Meeting note

File reference	EN010068
Status	Final
Author	Karl-Jonas Johansson
Date	6 March 2015
Meeting with	Millbrook Power Limited
Venue	Temple Quay House, Bristol
Attendees	Applicant (Millbrook Power Limited) Nick Johnson, STAG energy Paul Wormald, Peter Brett Consultants Richard Griffiths, Pinsent Masons Planning Inspectorate Ken Taylor (Infrastructure Planning Lead) Vicki Hodgson (Legal) Kay Sully (Case Manager) Karl-Jonas Johansson (Case Officer)
Meeting objectives	Draft Documents meeting
Circulation	All attendees

Comments on the Millbrook Power Draft DCO

For individual plans of Work Packages 1, 5, 6 and 7 see supplementary plans 2.6.1 to 2.6.11

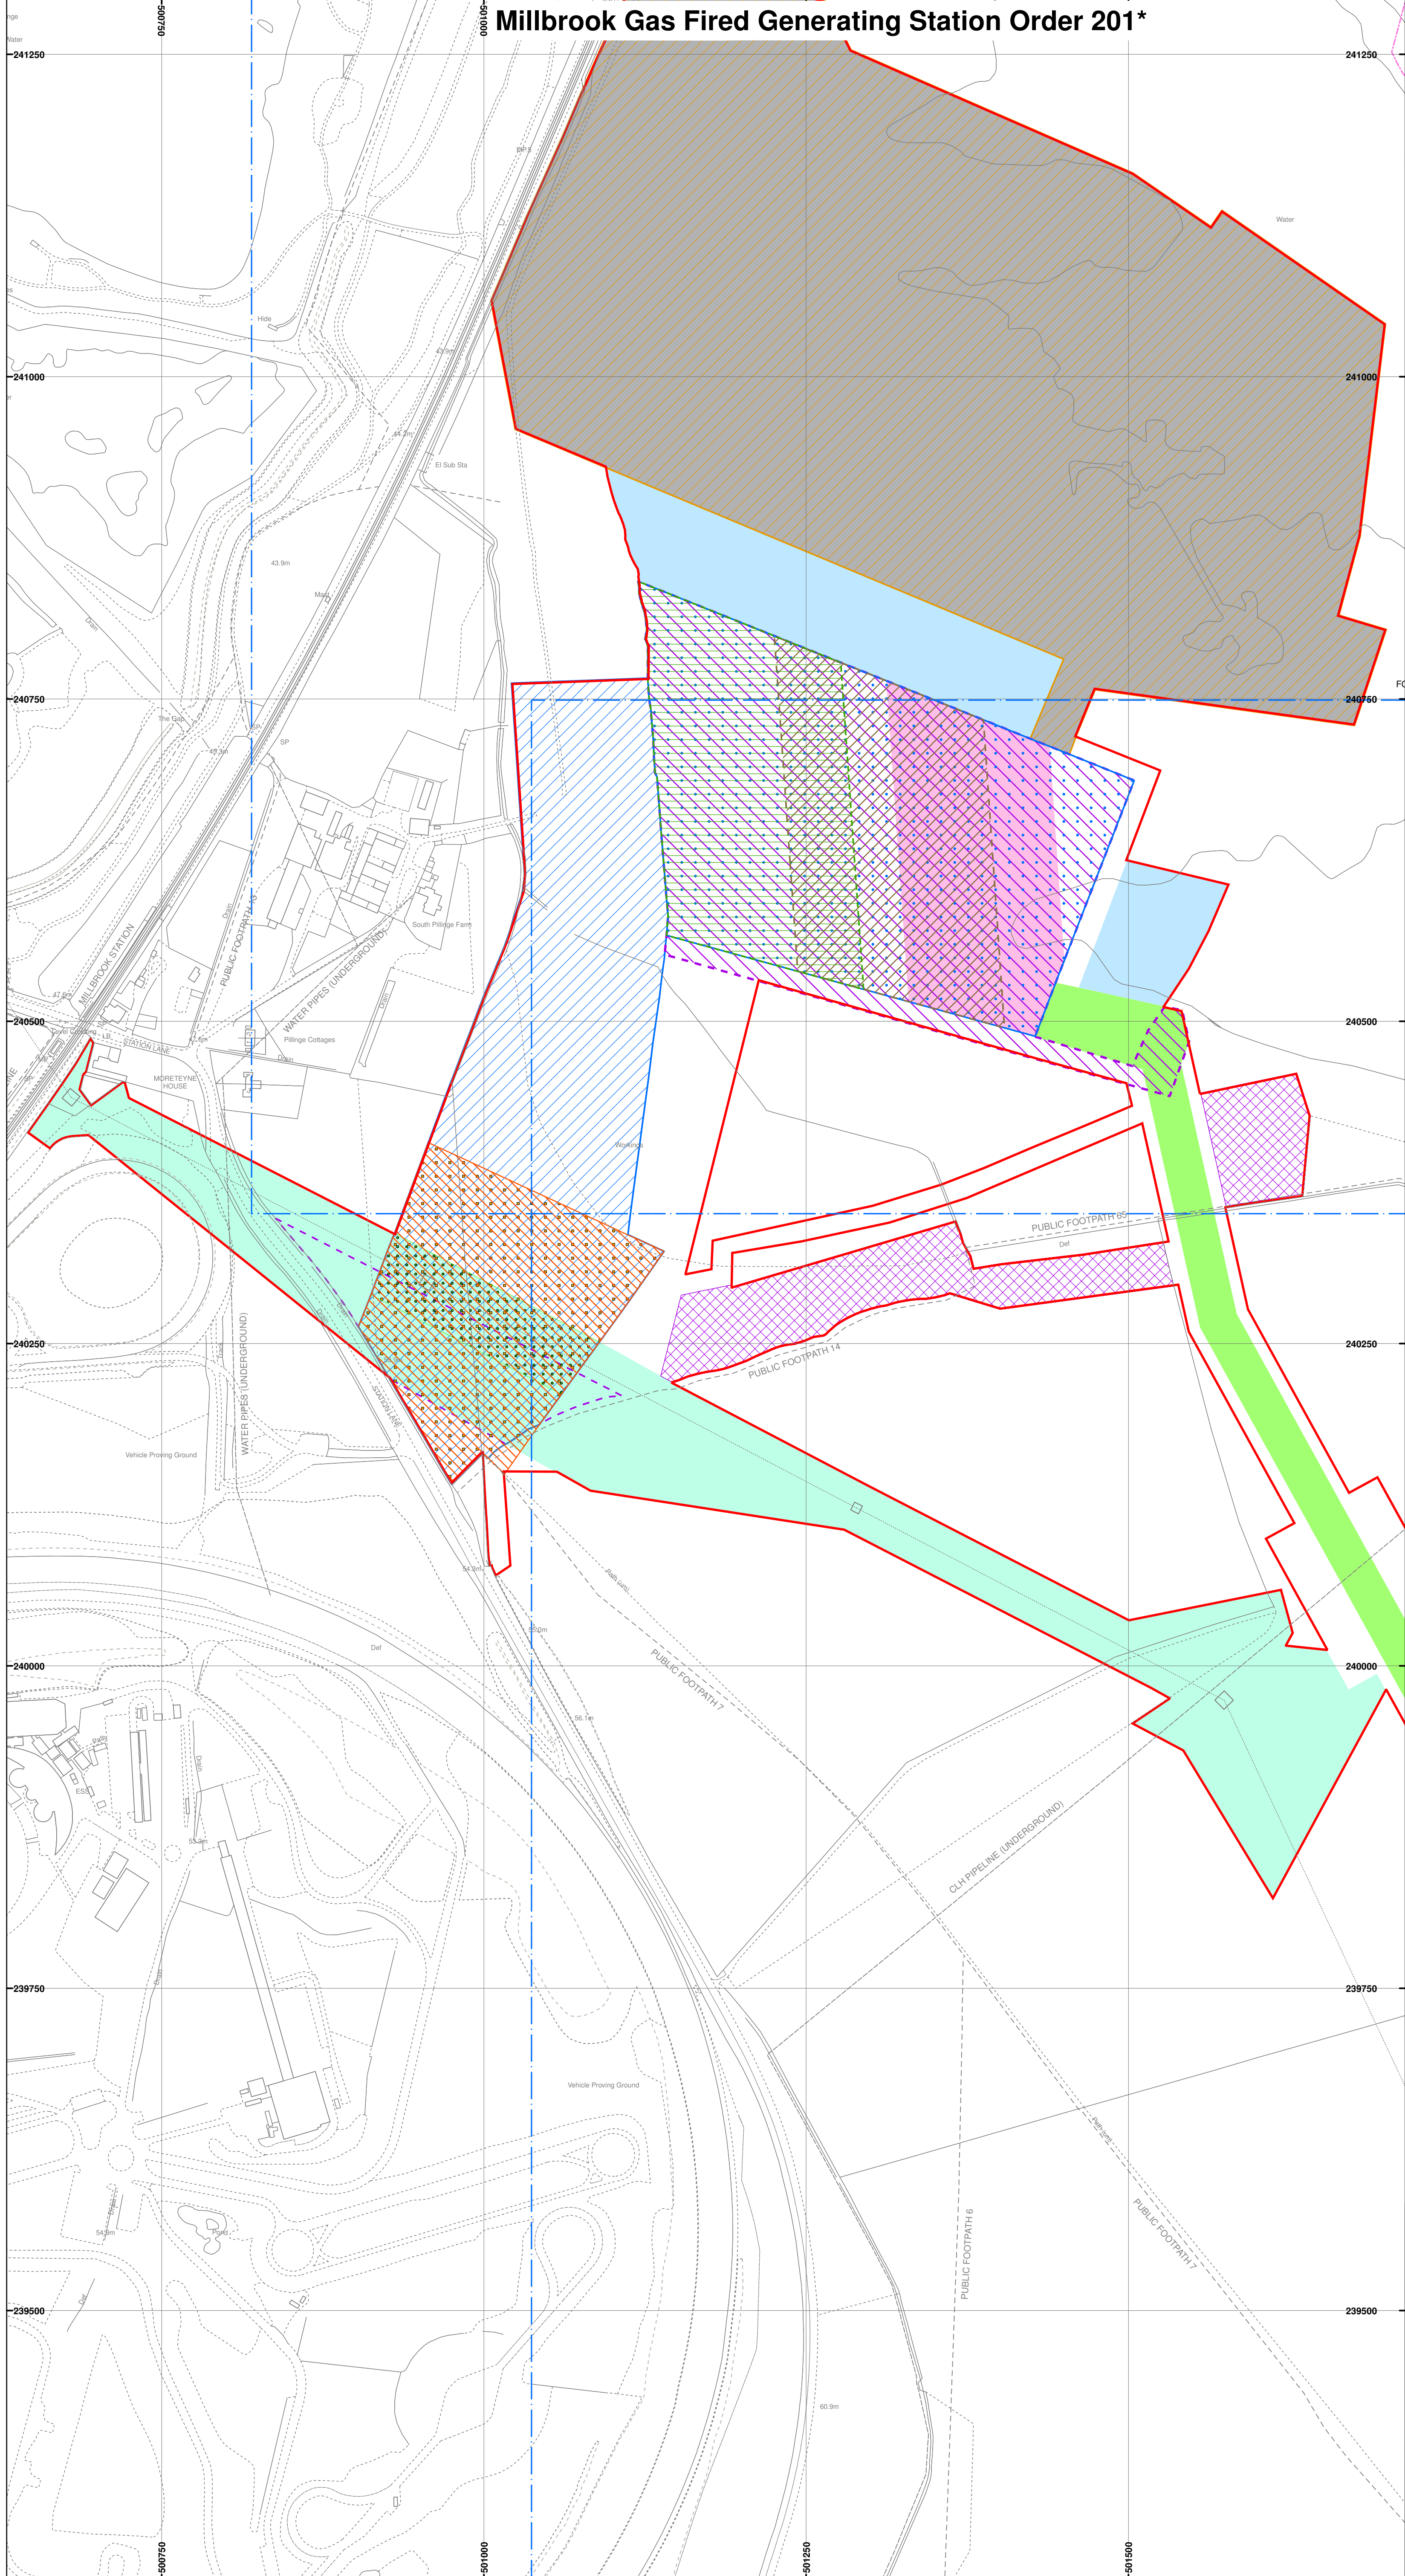
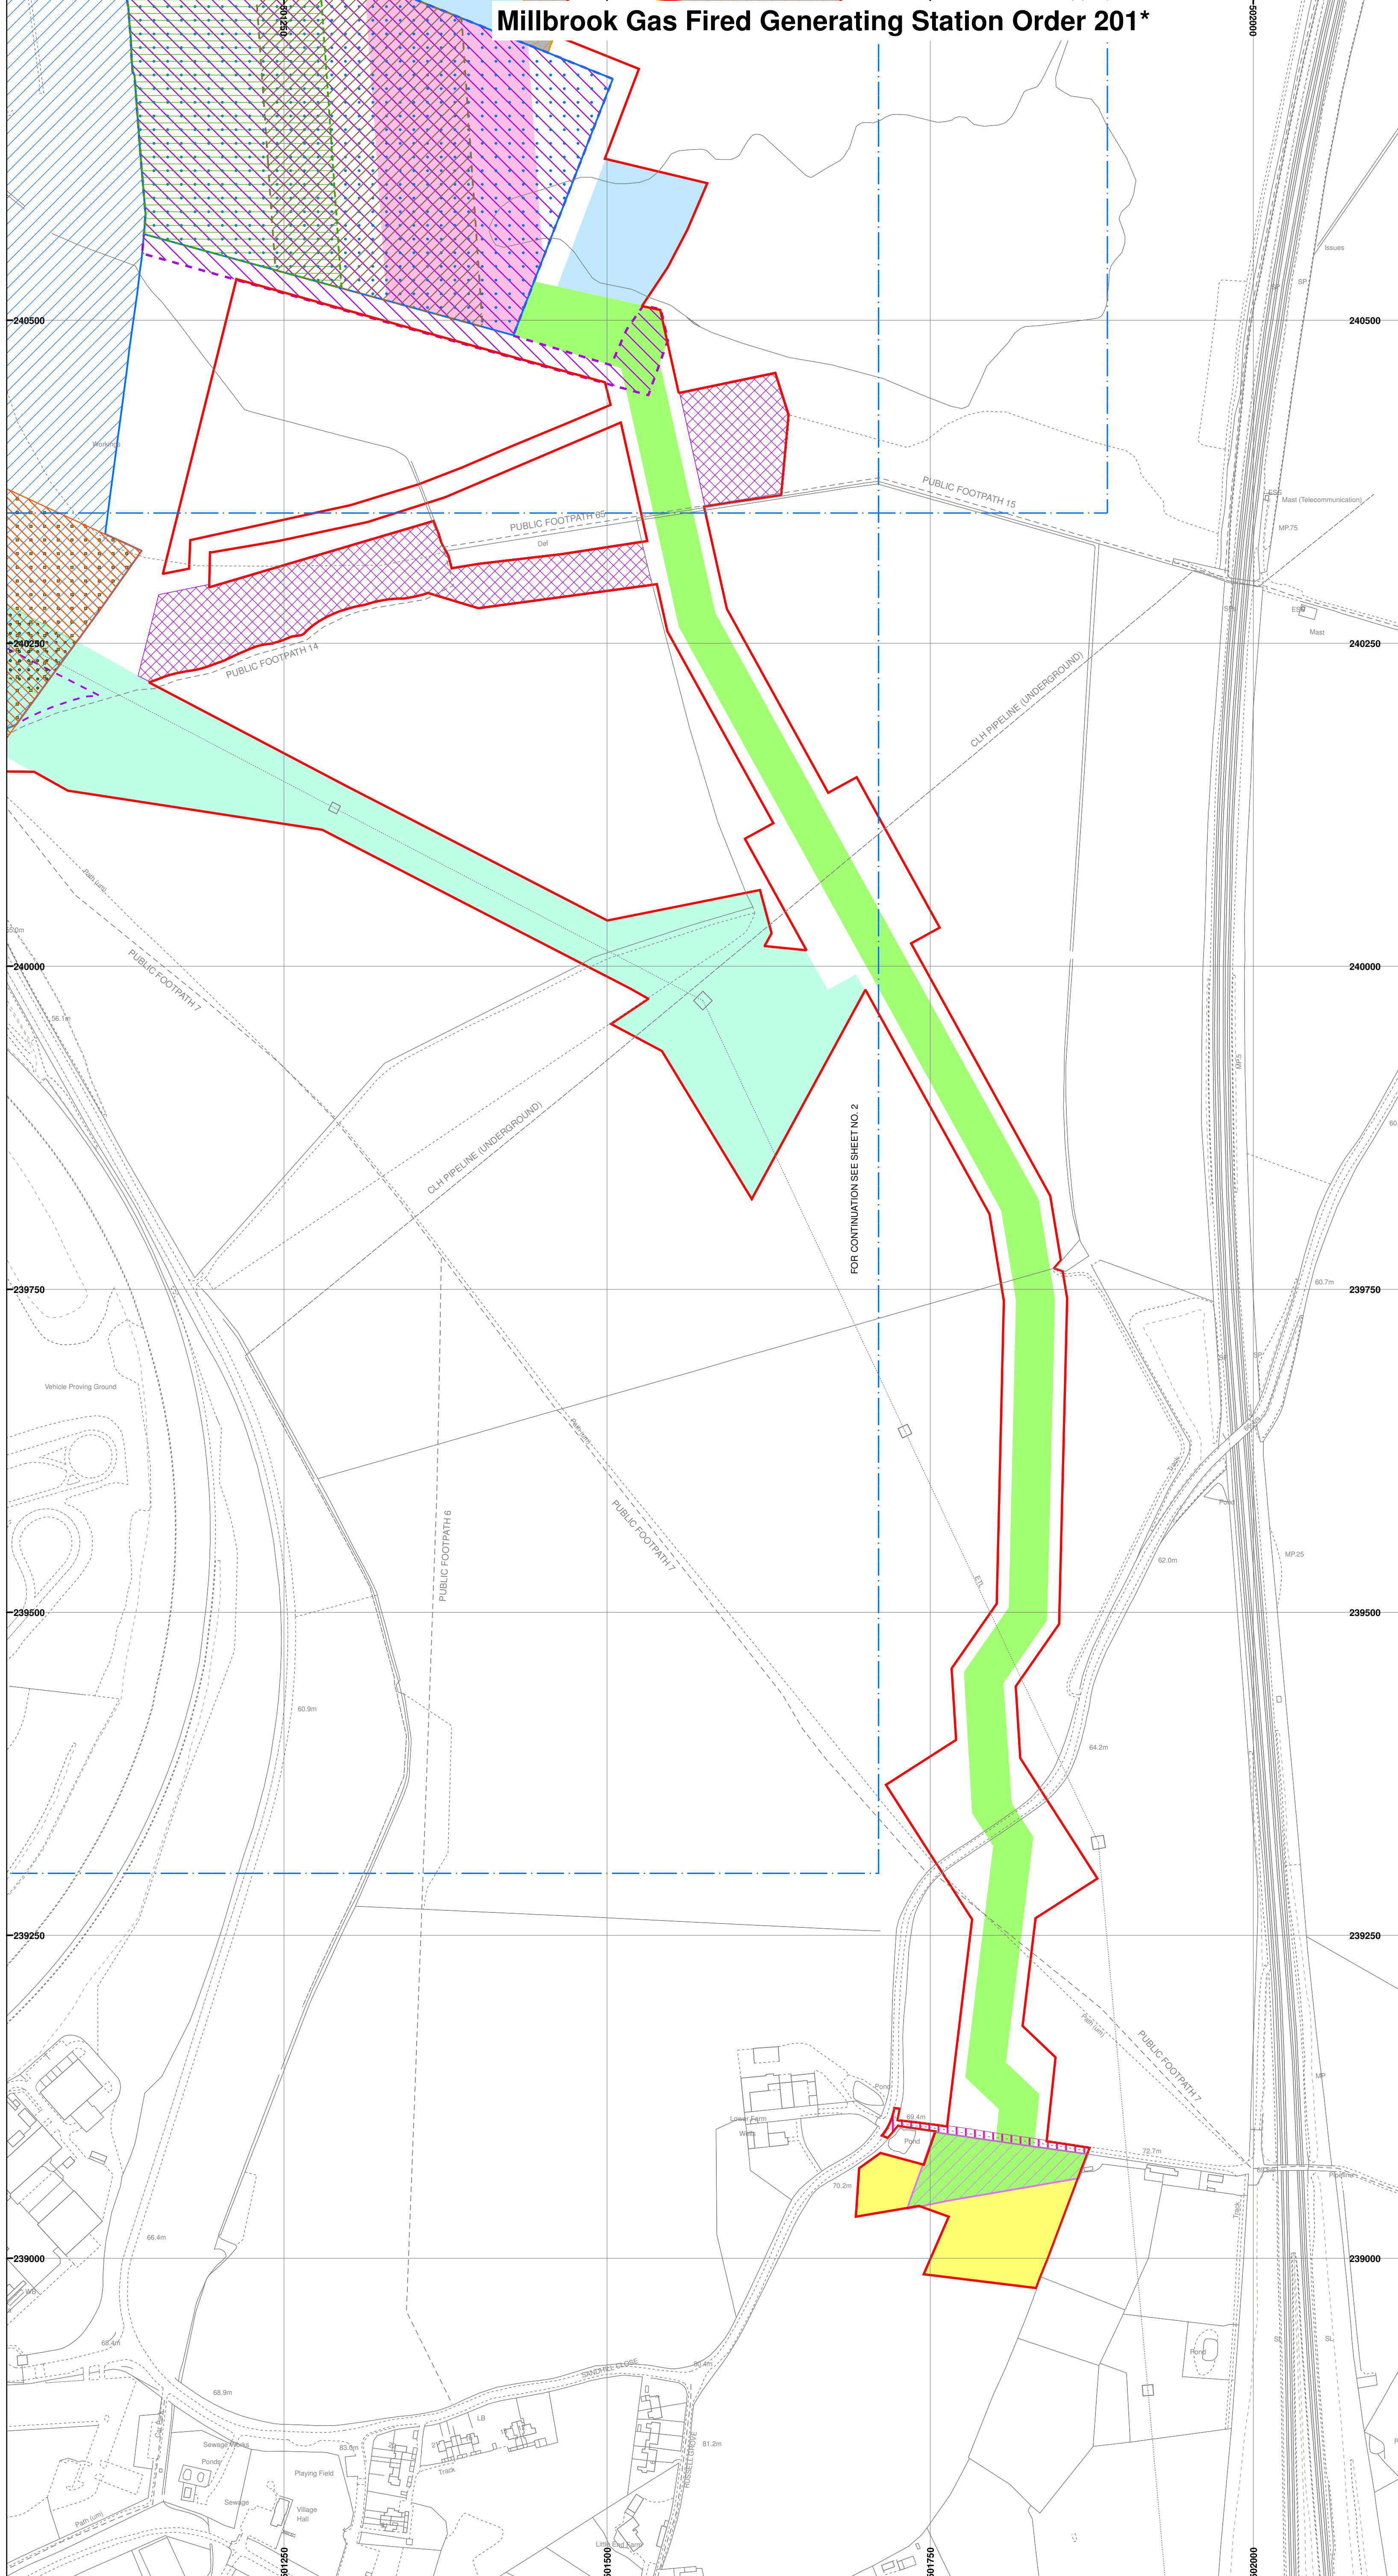
The applicant explained that the updated version of the DCO addressed the issue of some the works not being controlled in the previous version of the DCO. It was agreed that the applicant would check if works 1b, 1d and 3a was fully controlled in the updated version of the DCO. The applicant clarified that works 6a and b could be seen on the indicative layout plan but not on the works plans.

Work 6 – it is not immediately apparent why there are two options for Work 6. Are these in different locations (i.e. the northern and southern dotted areas on the Land Plans?) If so it may be helpful to annotate which is area 6A and 6B on the Land Plans.
